From: Amanda Scholes on behalf of Planning.Responses
Sent: 24 October 2017 09:05
To: Planning Scanning
Subject: FW: Planning Consultation on BR/208/17/DOC

Consultation response from Drainage and coastal engineer

APPLICATION **BR/208/17/DOC**
NO:

Site Address: Villa Maria Campbell Road Bognor Regis PO21 1NW

PROPOSED SITE PLAN  
(1:100)

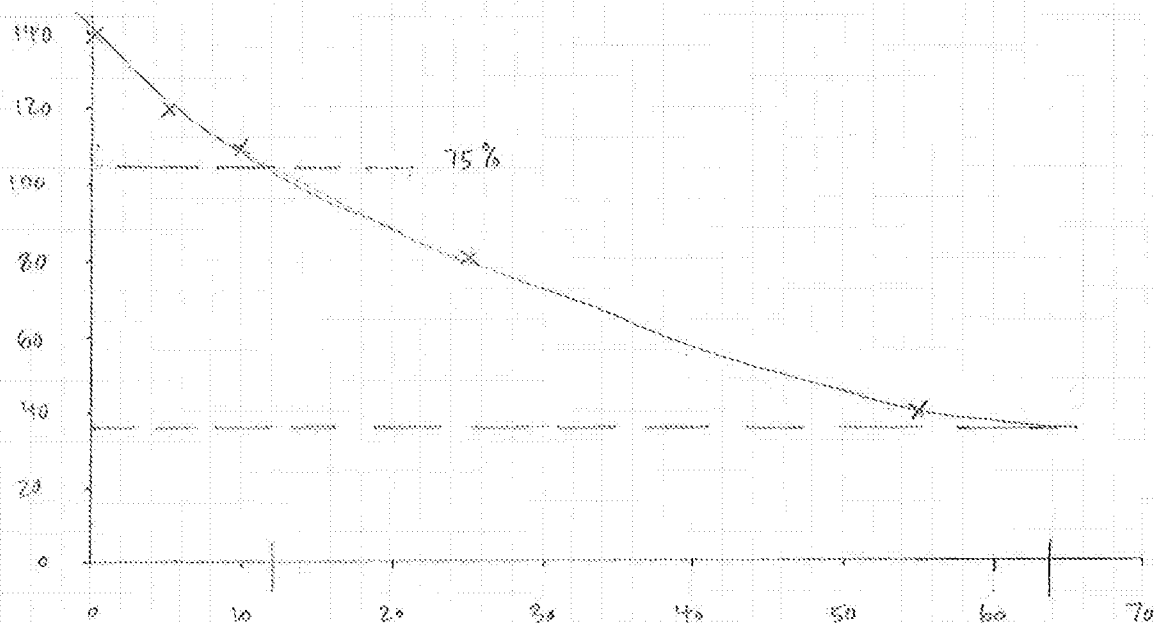
There appears to be insufficient room to accommodate traditional crate soakaways (for the roof water), due to the proximity of buildings, etc. Even if traditional soakaways could be installed, there is insufficient winter groundwater monitoring and winter percolation testing data to support any design. As a result of there being insufficient room, they seek to connect to the public foul sewer in Campbell Road.

The discharge of surface water to the public foul sewer in Campbell Road would not be acceptable. There may be a highway drain in Campbell Road, which may ultimately discharge into the Waterloo Road public surface water sewer. This would need to be proven. A connection to the highway drain (if possible) would require West Sussex County Council approval and flows would need to be attenuated. The applicant should fully investigate this matter, before further consideration.

It may be possible to discharge roof water into permeable paved areas, subject to Building Control approval, further testing/monitoring, calculations, etc?

### TRIAL HOLE RESULTS.

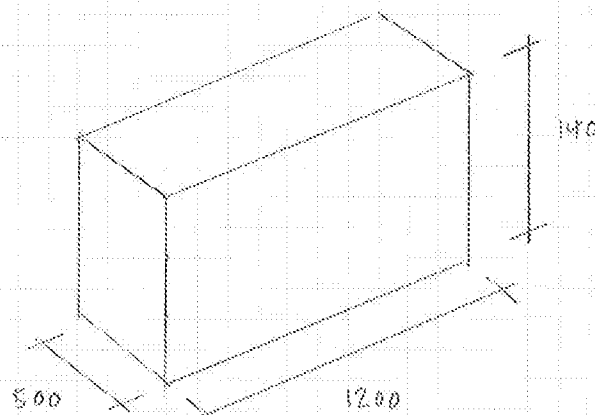
The applicant has undertaken insufficient winter groundwater monitoring and percolation testing (to only 140mm deep) to prove the use of soakaways. Utilising permeable paving for the surface areas is fine in principle subject to further percolation tests being undertaken at an agreed time in the winter. These will need to be carried out to a depth equivalent to the formation level of the permeable paving and at the location of the structures.
